From: Mira Latoszek <mira.latoszek@gmail.com>
Sent: Thursday, December 7, 2017 3:21 PM
To: Nicole Gaudette
Subject: Comment regarding potential development at 4825 East Mercer Way, Mercer Island, WA, 98040 (File No. CA017-010)

I am writing in objection to the potential development at 4825 East Mercer Way, Mercer Island, WA, 98040 (File No. CA017-010). After reviewing the plan documents, it is clear that the proposed development impinges too far into the wetland and is close the endangered species protection zone around the Douglas Fir tree. Please do not approve averaging of the 50-foot Type II stream buffer using buffer averaging (MICC 19.07.070(B)(3)) and the reduction of the Type III wetland buffer from 50-feet to 25-feet using buffer reduction.

**CRITICAL AREAS MITIGATION PLAN
 PROPOSED SITE PLAN, IMPACTS & MITIGATION PLAN
 HOU PROPERTY
 MERCER ISLAND, WA**

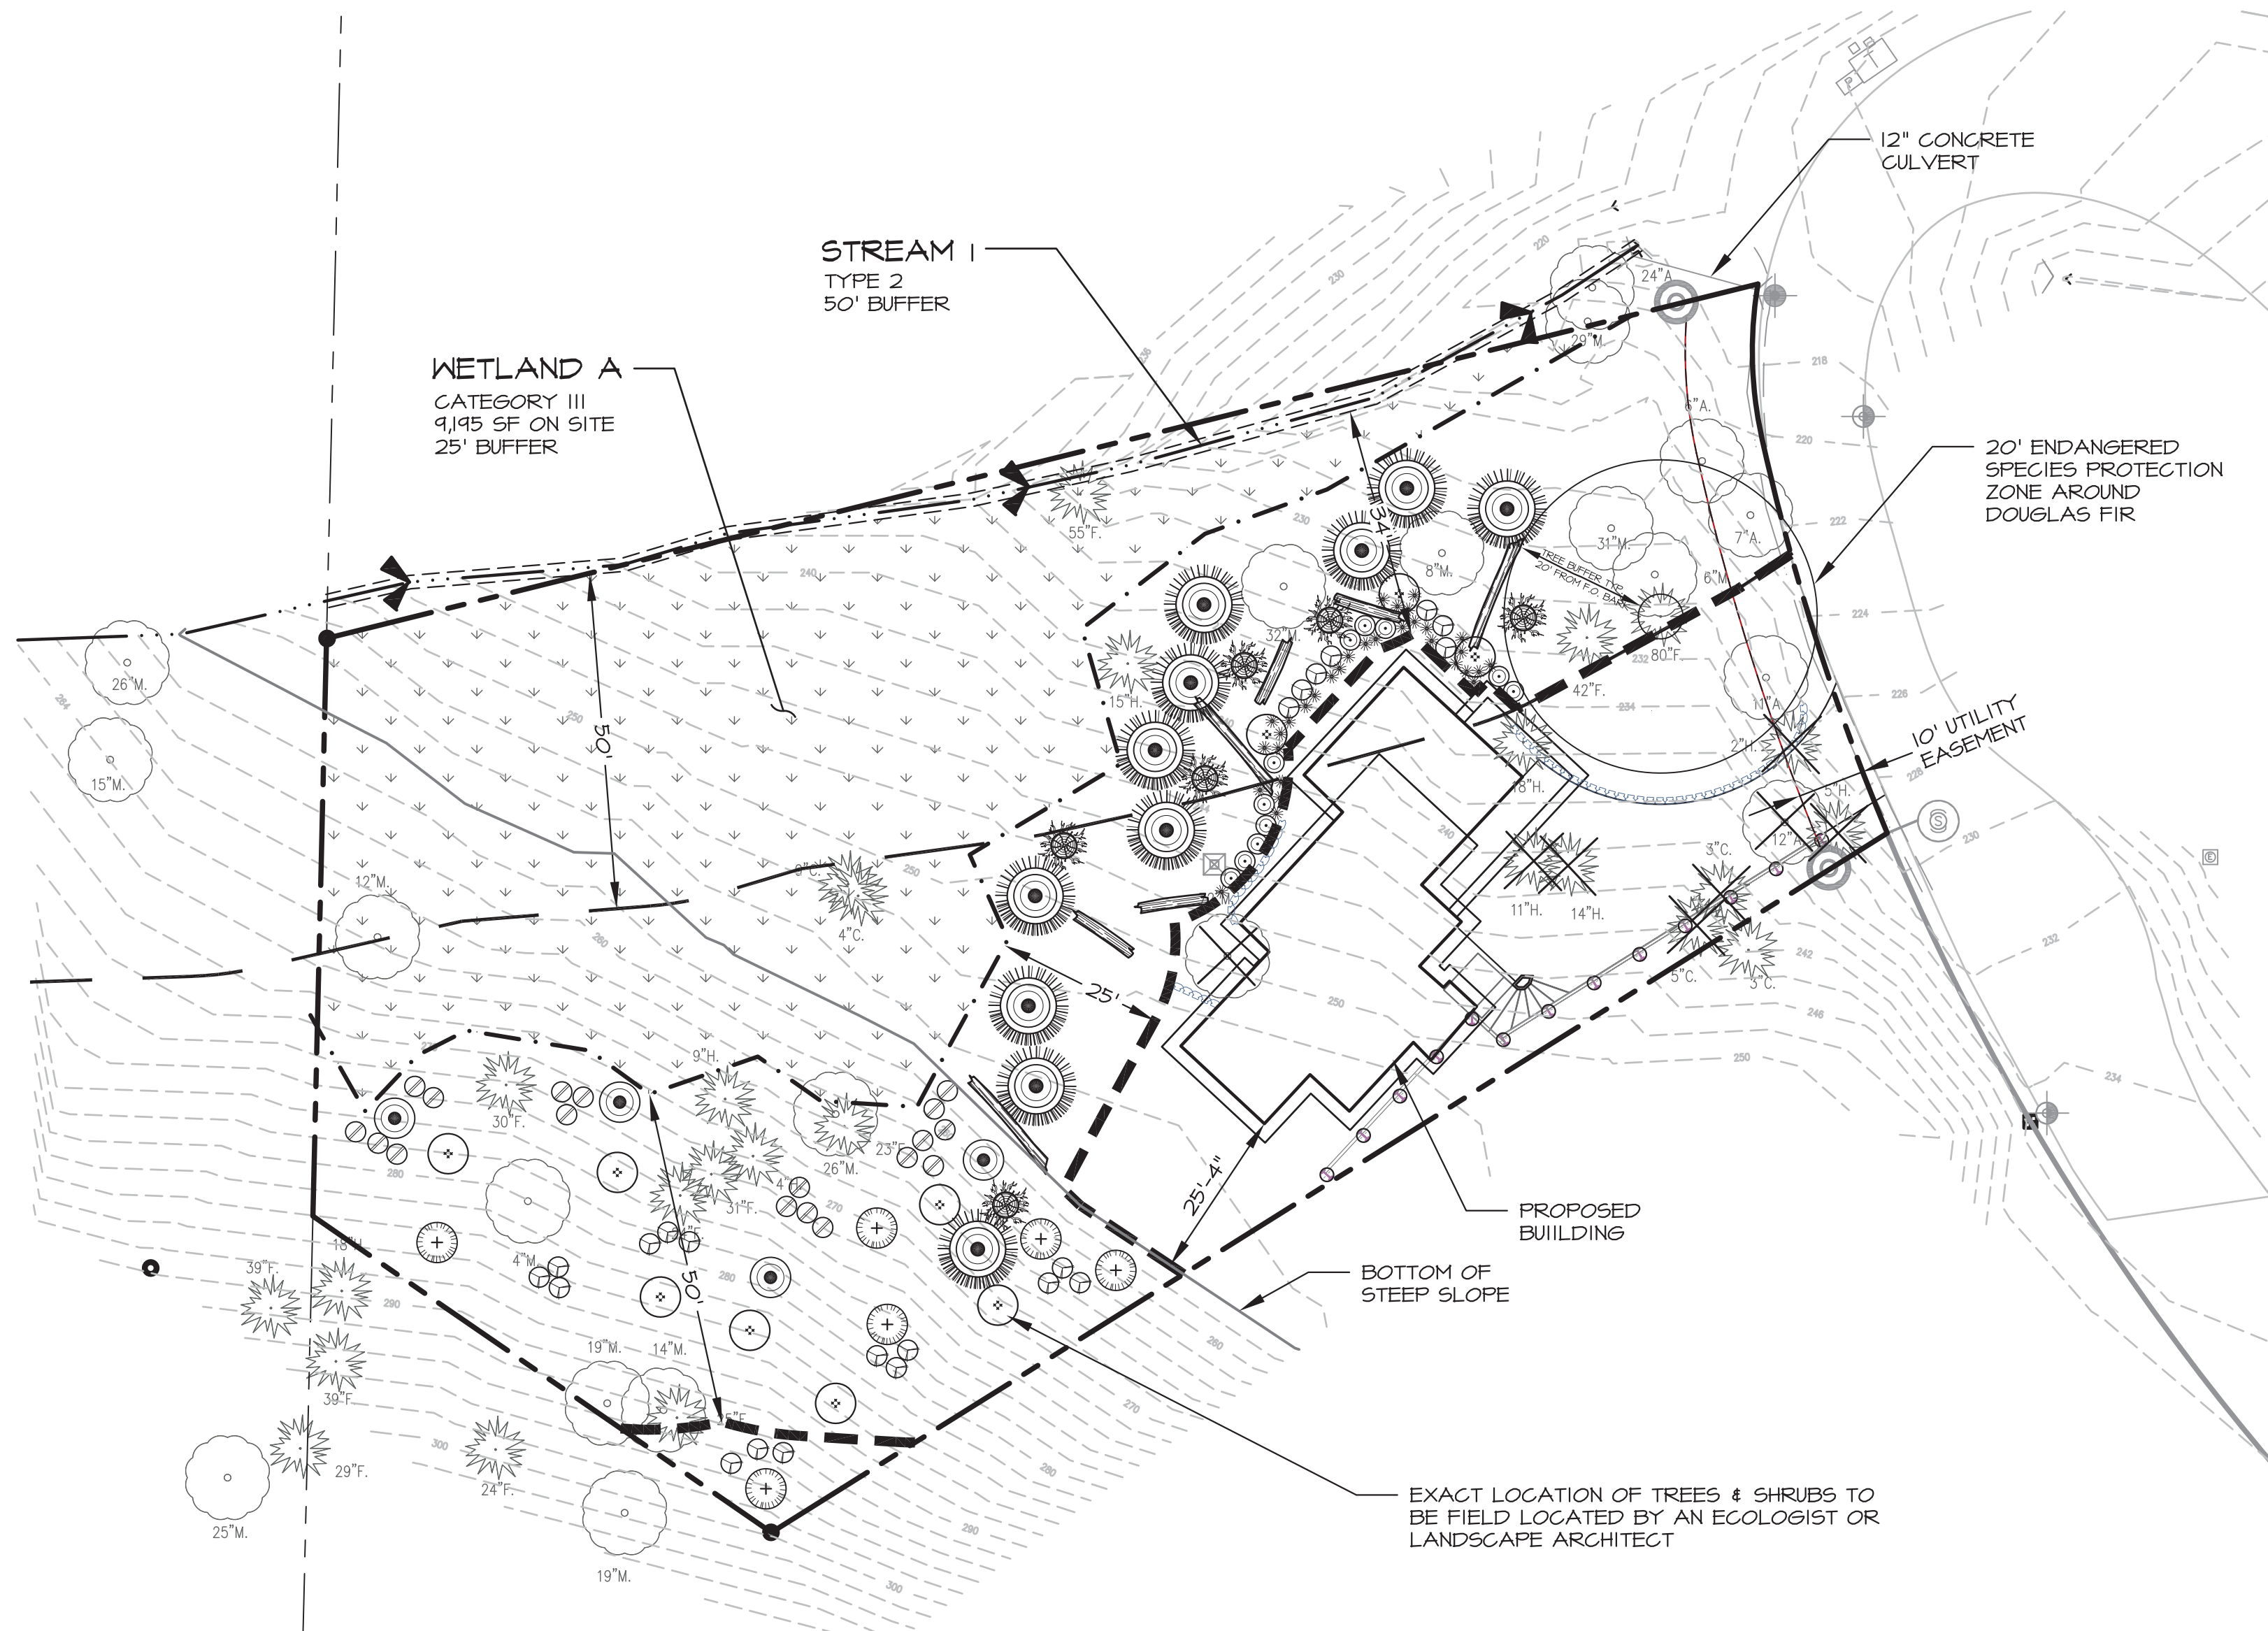
The proposed building should be reduced in size so the it and the construction impact area fit into the area outside the stream buffer. The endangered species protection zone around the Douglas Fir tree should be enlarged to 100 feet to protect the 300+ year old Douglas fir as it's root structure radiates in every direction for a great distance, including into the stream course.
